## SUBMISSION 2: SUMMARY OF ADDITIONAL CONCERNS IN RELATION TO THE PROPOSED NORTHCONNEX TUNNEL

Application number - SSI 13\_6136

**This is an objection to many aspects of the proposed NorthConnex tunnel.**

MOTORWAY OPERATIONS COMPLEX - SOUTHERN VENTILATION FACILITY - SECTIONS
M1-M2-5000-DR-JD-0525

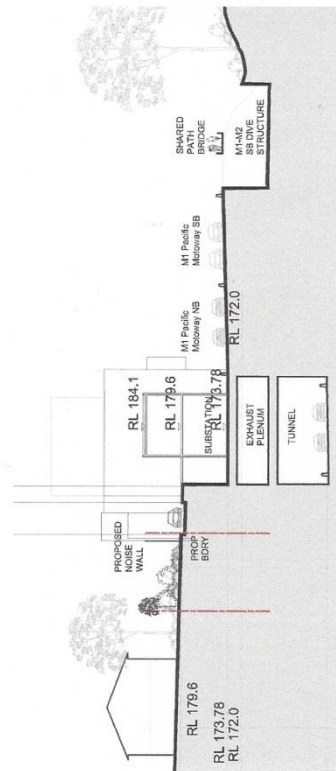
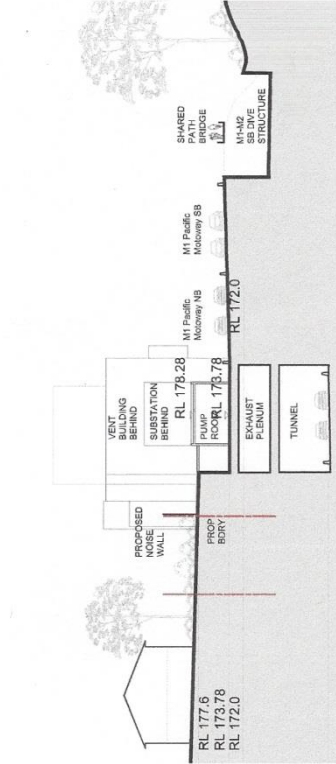
Speakers at the NorthConnex Air Quality Forum spoke of the importance of the topography in the placement of the ventilation facilities. In the NorthConnex proposal the southern ventilation facility is at the lowest point of the M2 intersection where it is surrounded on three sides by hillside cuttings. In this location the “discharge point” will barely be above the adjacent high ground.

Much is made of the intention to discharge the polluted air through the stack at 13 – 19m/s. Given that the stack is only 15m above Pennant Hills Road, a simple calculation indicates that the particles will be ejected to a height of between 23m and 33m above Pennant Hills Road. That will only be sufficient for them to be dispersed by prevailing winds IF there is wind and it is strong enough. For instance, the weather history graph showing the wind speed and direction at West Pennant Hills measured on the 24th August 2014 indicated that there was no wind until 9am and what wind there was, came from the west. Wind speeds of less than 2m/sec (ie about 8km/hour) are not considered sufficient to disperse pollution from the stack. Only a very few gusts on this day were in excess of 8km/hour.

That the Government ensures that the southbound ventilation facility ie the Stack, be located at the south-west corner, on the RMS owned land, at the edge of the Pennant Hills Golf course. In this location, the southbound tunnel can be efficiently, effectively and economically ventilated.

The impact of the stack plumes on the surrounding residential areas must be modelled using its current proposed position and height and also modelled with the stack positioned on the golf course side of Pennant Hills Road, where it is topographically higher. This would allow an objective, impartial, scientifically based assessment to be made of the most effective location for the stack.
